**KIRKLEES METROPOLITAN COUNCIL  
INVESTMENT & REGENERATION SERVICE**

**DELEGATED DECISION TO DETERMINE PLANNING APPLICATIONS**

Reference No:	<b>2026/62/90432/W</b>
Site Address:	19, Ellison Street, Crosland Moor, Huddersfield, HD4 5DS
Description:	Erection of side and rear extensions
Recommending Officer:	Joshua Merriman

## **Officer Report – 2026/90432**

DATE: 23.10.2025	SCALES: AS SHOWN @ A1.	DRAWING NUMBER: PAD.220.267	REVISION:
DRAWN: M.A.	CHECKED: M.A.	APPROVED:

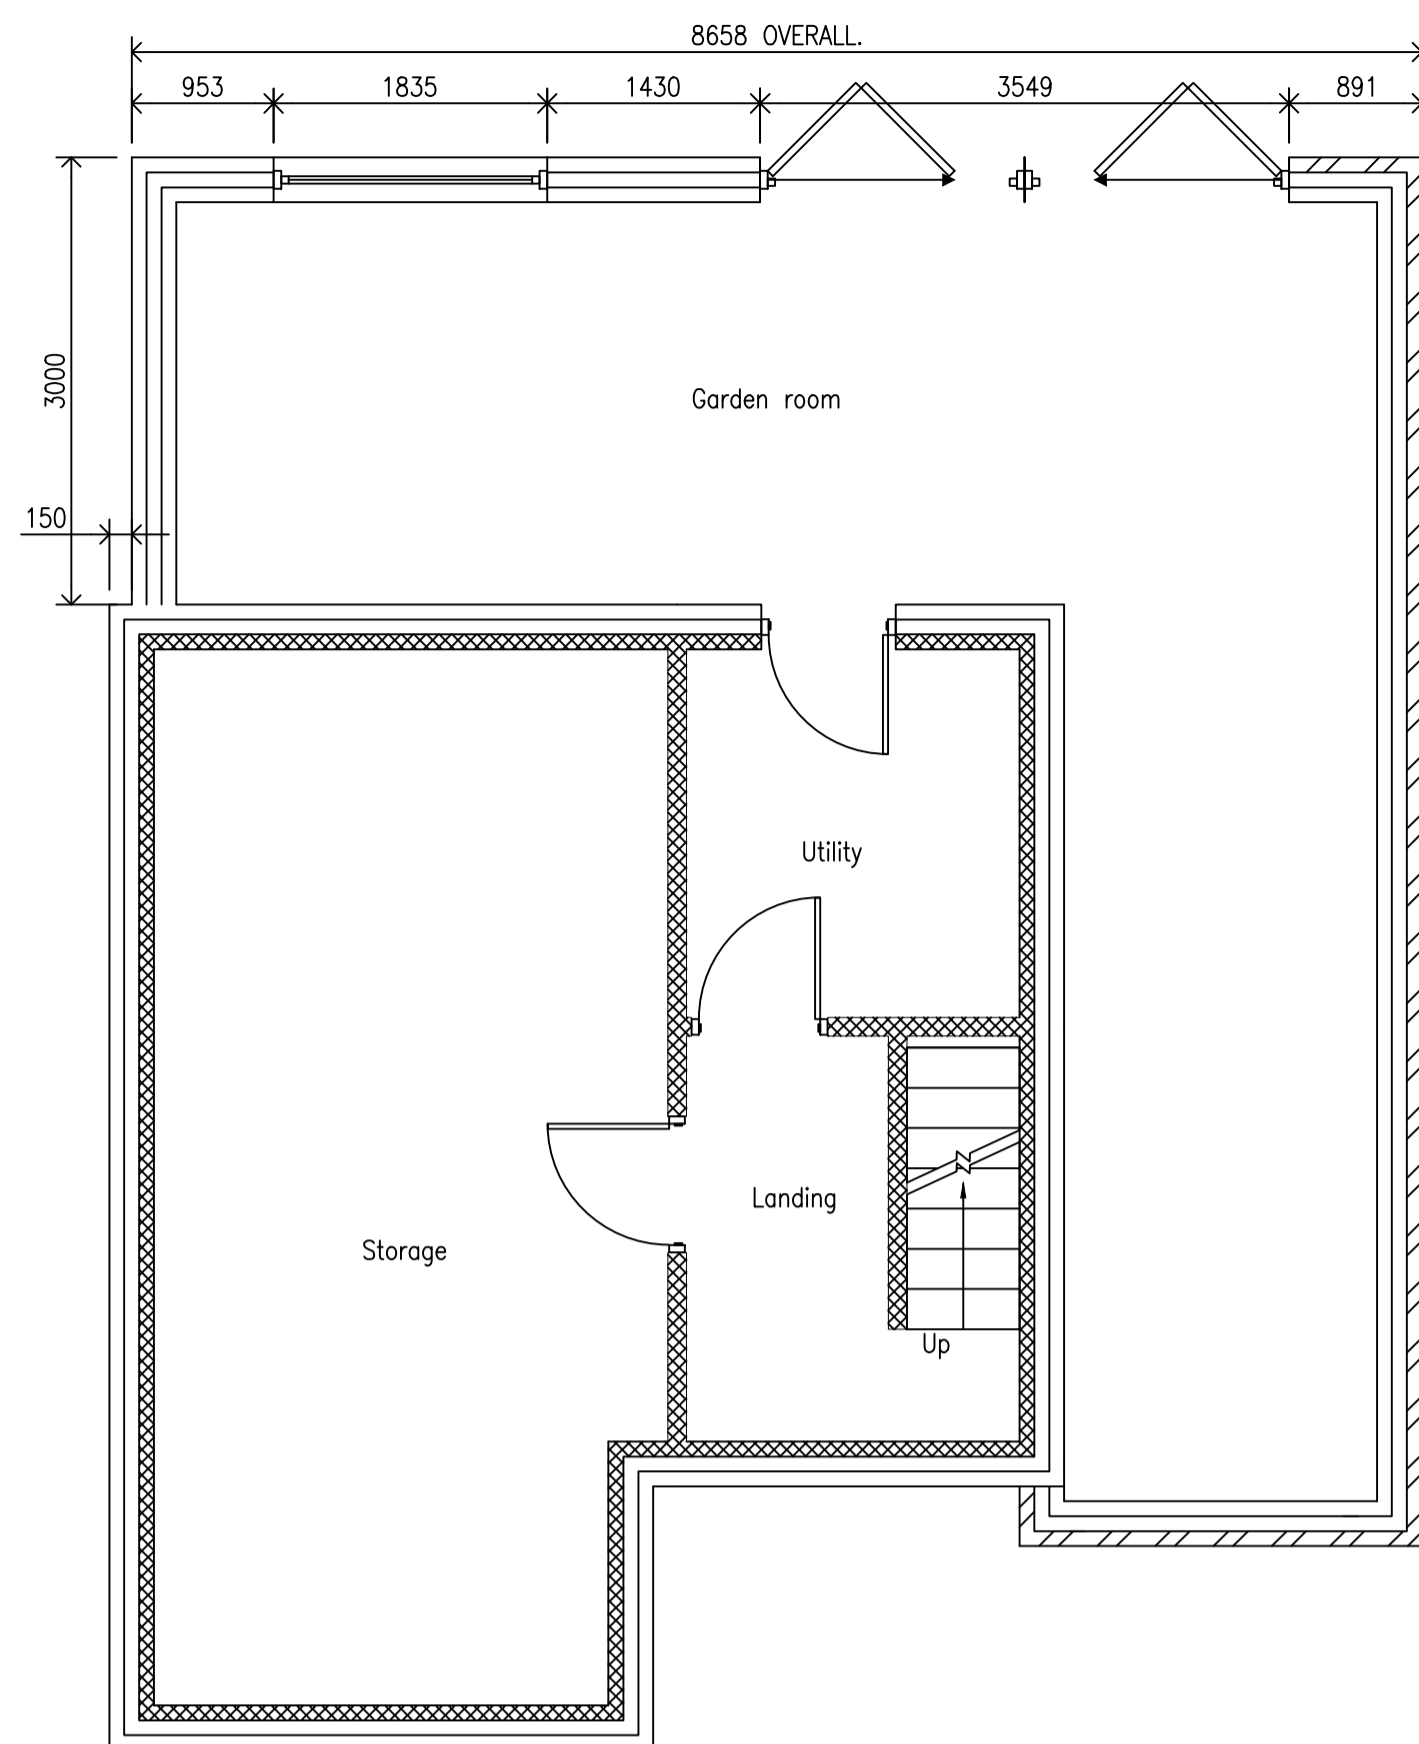
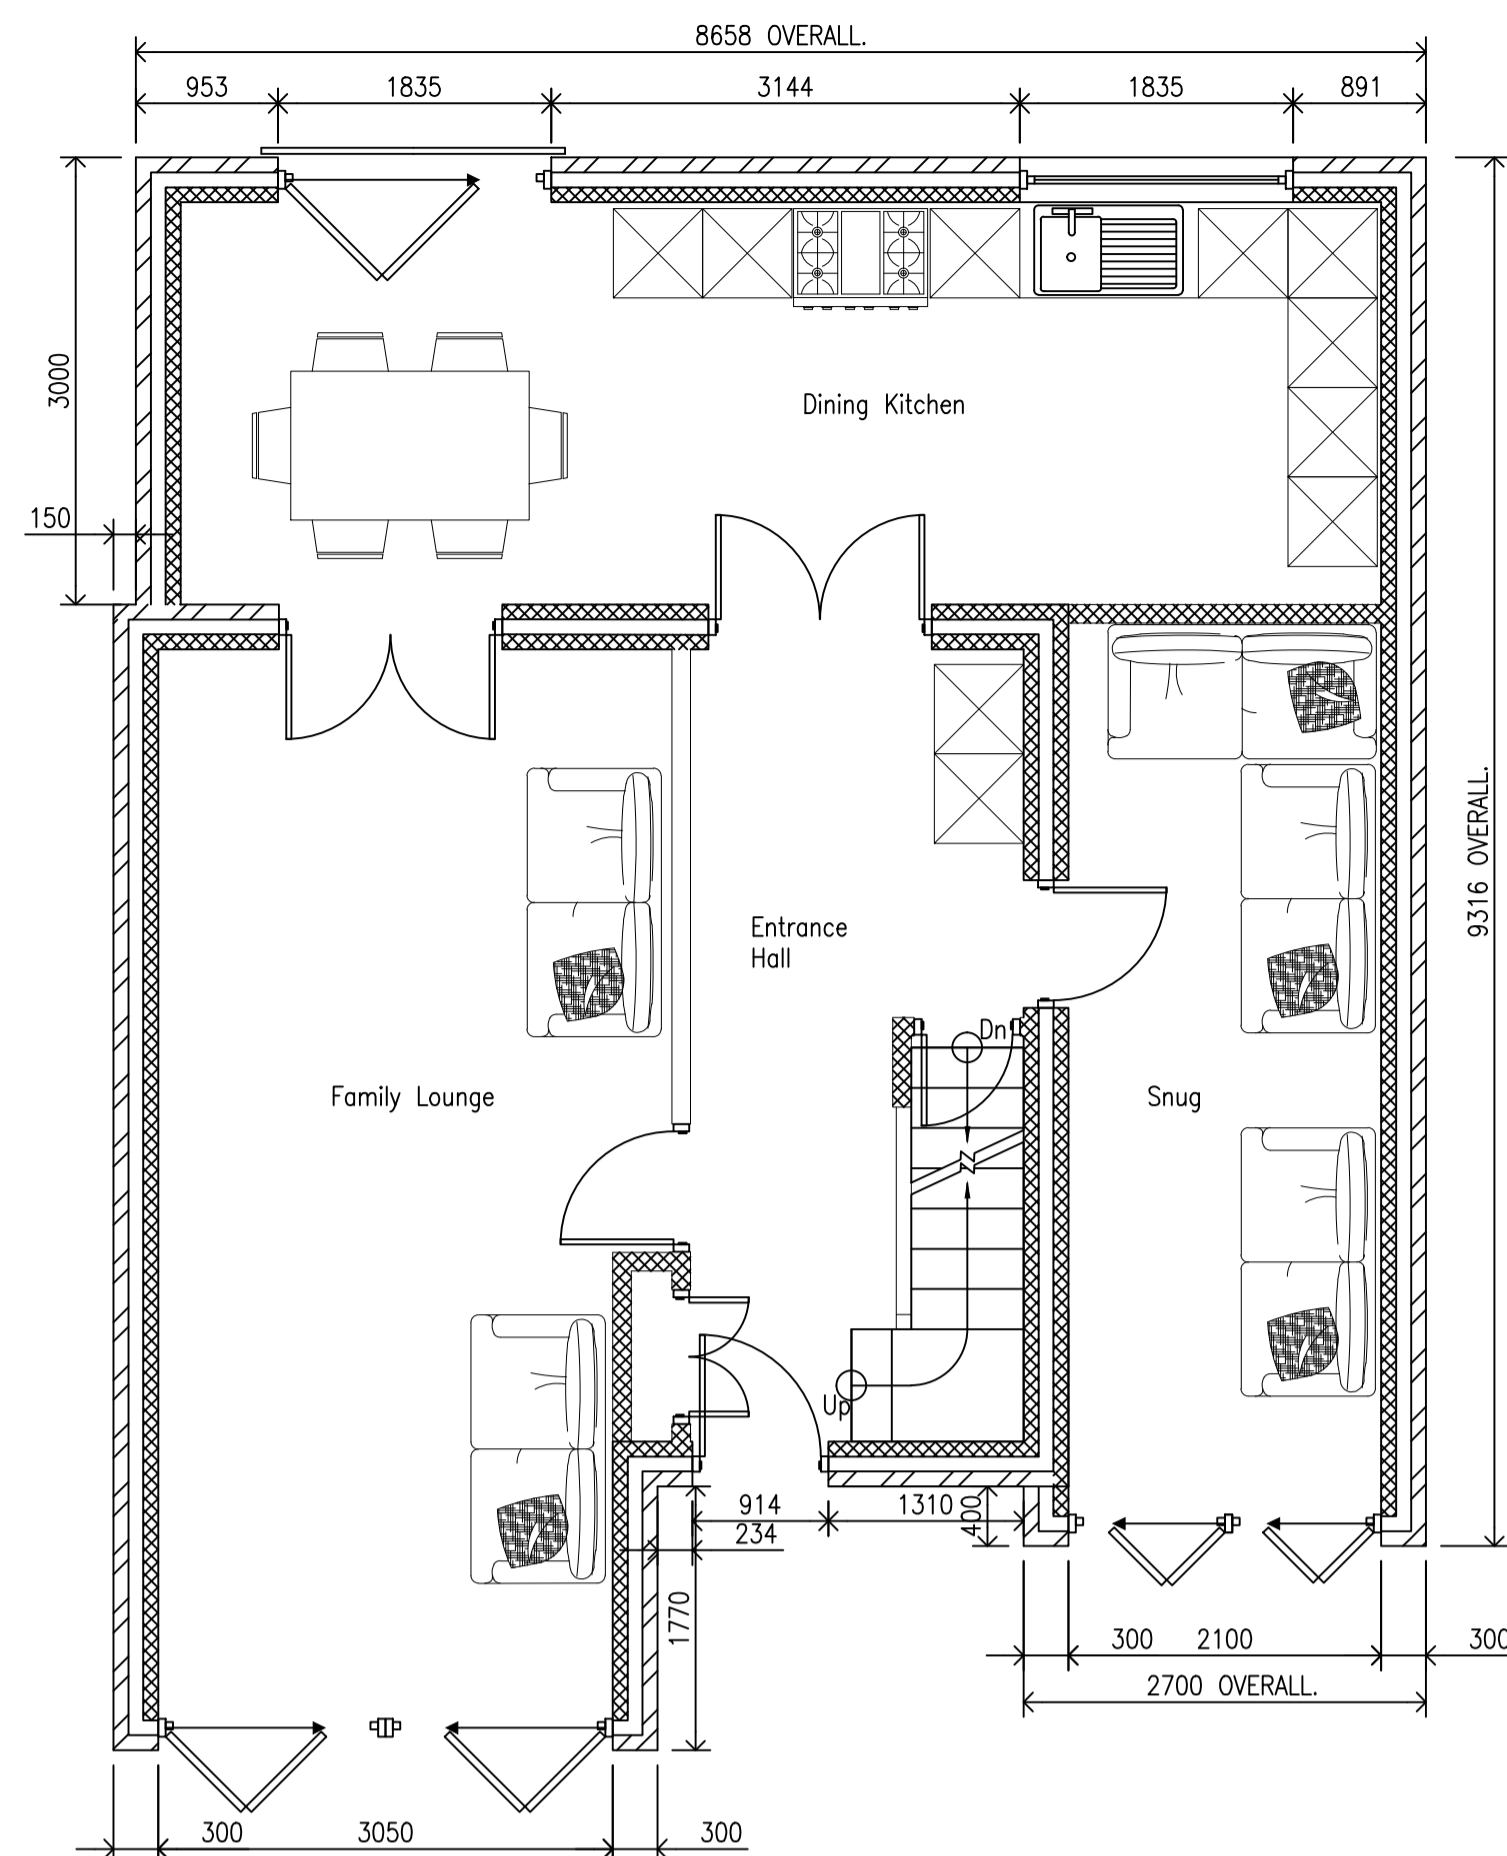
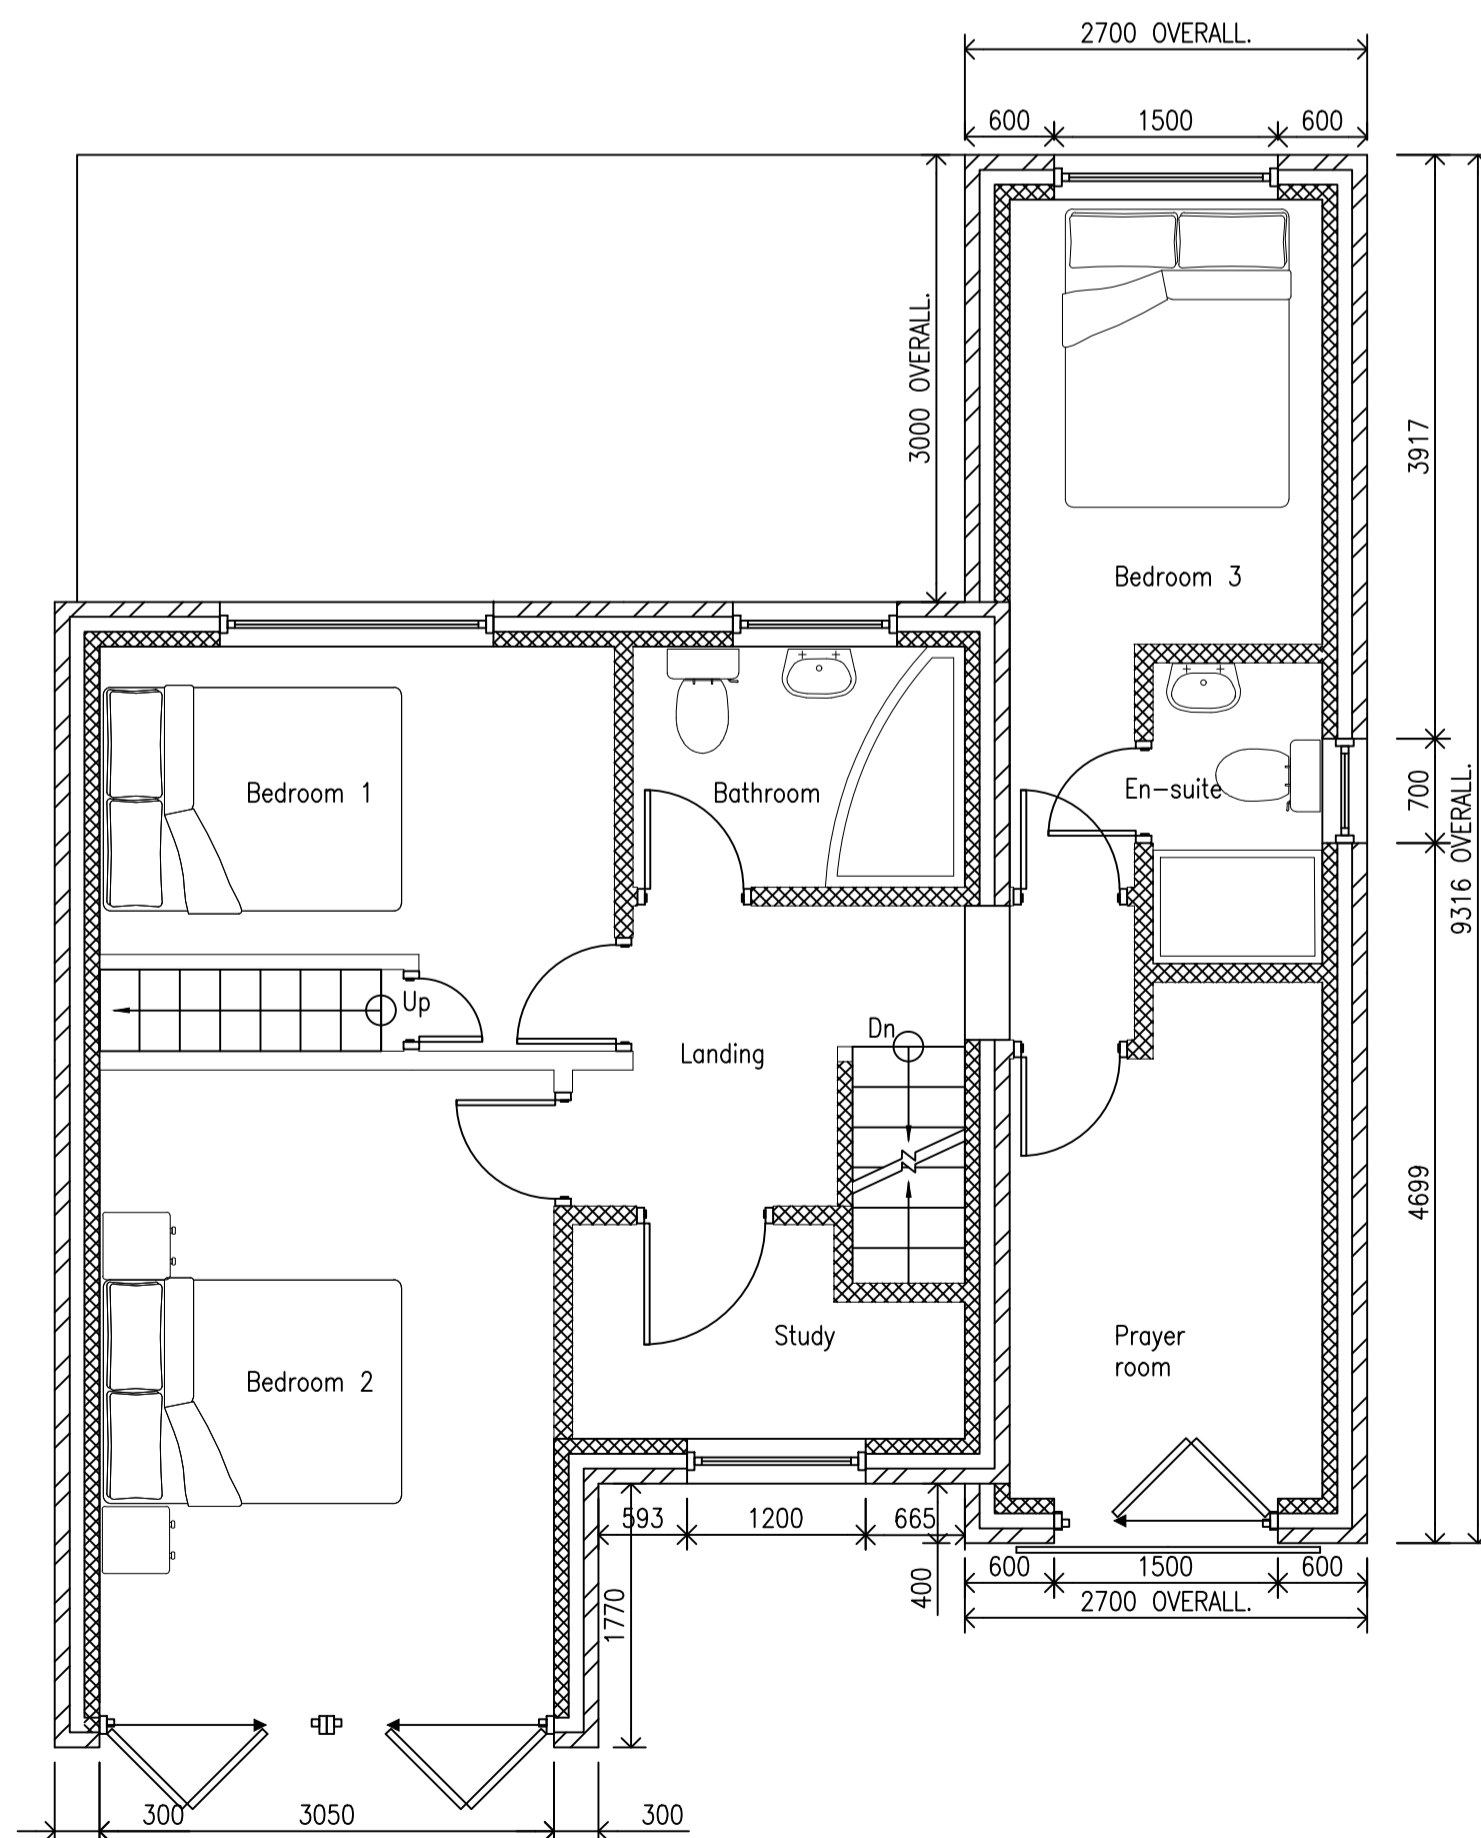
The proposed side and rear extensions, given their wraparound nature, would provide no external access to the rear garden on site, and would not retain a 1m gap to the neighbouring property to the East. As this neighbouring dwelling is a bungalow, it is also considered that there would be overshadowing impacts upon the rear amenity space and Western facing openings throughout the afternoon given the scale of the proposed extensions in comparison to the single storey property.

Despite this, the overshadowing and overbearing impacts onto No. 21 are considered significant and it is therefore considered that in terms of residential amenity, the proposed would not comply with Policy LP24 of the Kirklees

1. By virtue of its scale, height, proximity, and orientation relative to the neighbouring bungalow at No. 21 Ellison Street, the proposed development would result in unacceptable overshadowing and overbearing impacts, causing harm to the residential amenity of the neighbouring occupiers, and would therefore be contrary to Policies LP1, LP2, and LP24 of the Kirklees Local Plan and Policies within Chapters 2 and 12 of the National Planning Policy Framework.

PROPOSED STREET SCENE.
SCALE 1:50

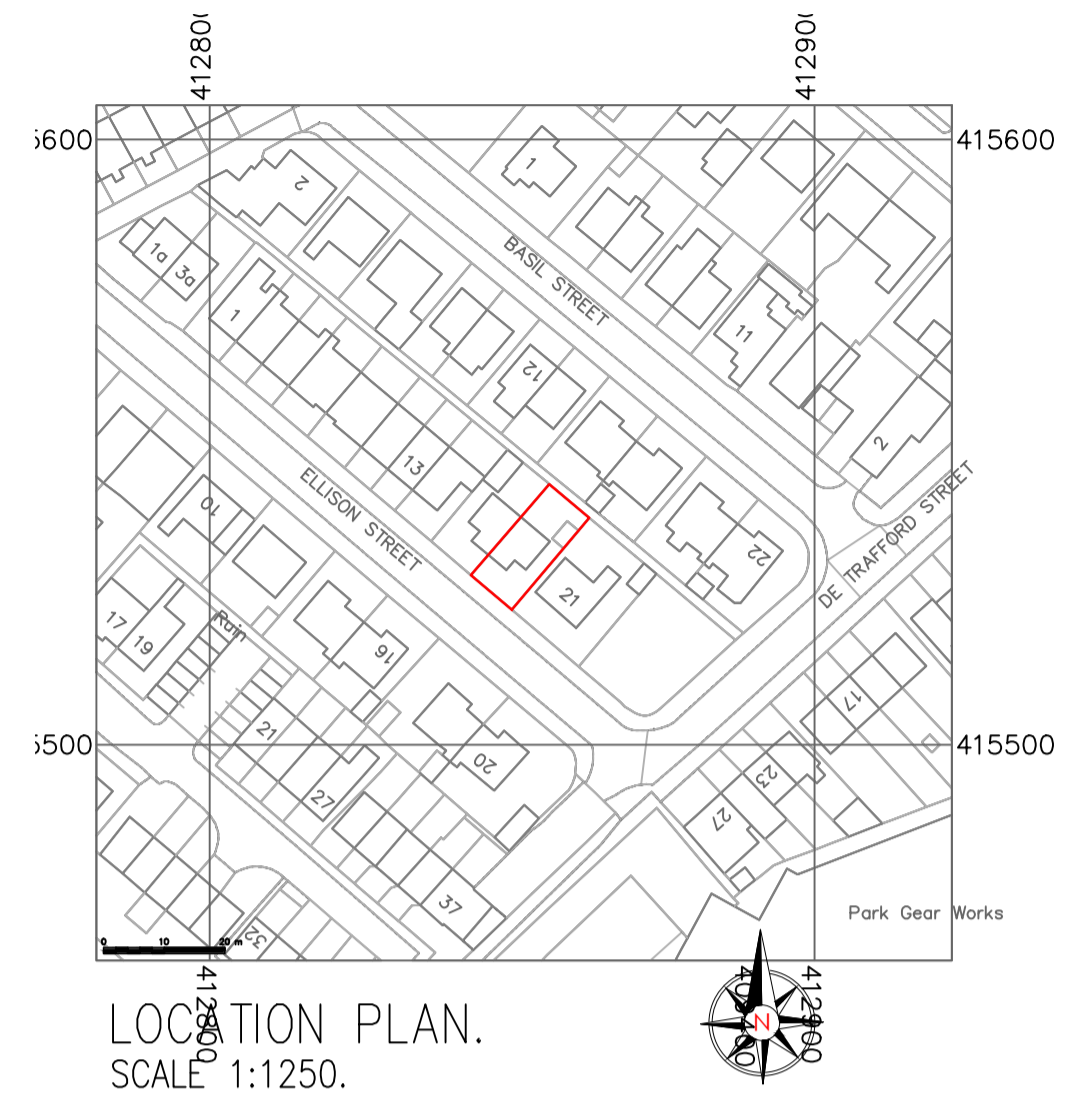
Given the contemporary style of the proposed extensions, using glass facades, breeze block, and render rather than stone and pebbledash to match the existing building, it is considered that the proposed frontage of the property, and two storey side extension would appear unsympathetic to the host property or the surrounding street scene, which is characterised by traditional properties, most of which are bungalows.

Furthermore, by virtue of these contemporary extensions, the additions to the application property would result in unbalancing a pair of semi-detached properties, with the application property and adjoined dwelling appearing different in character and appearance, thus negatively impacting the surrounding street scene.
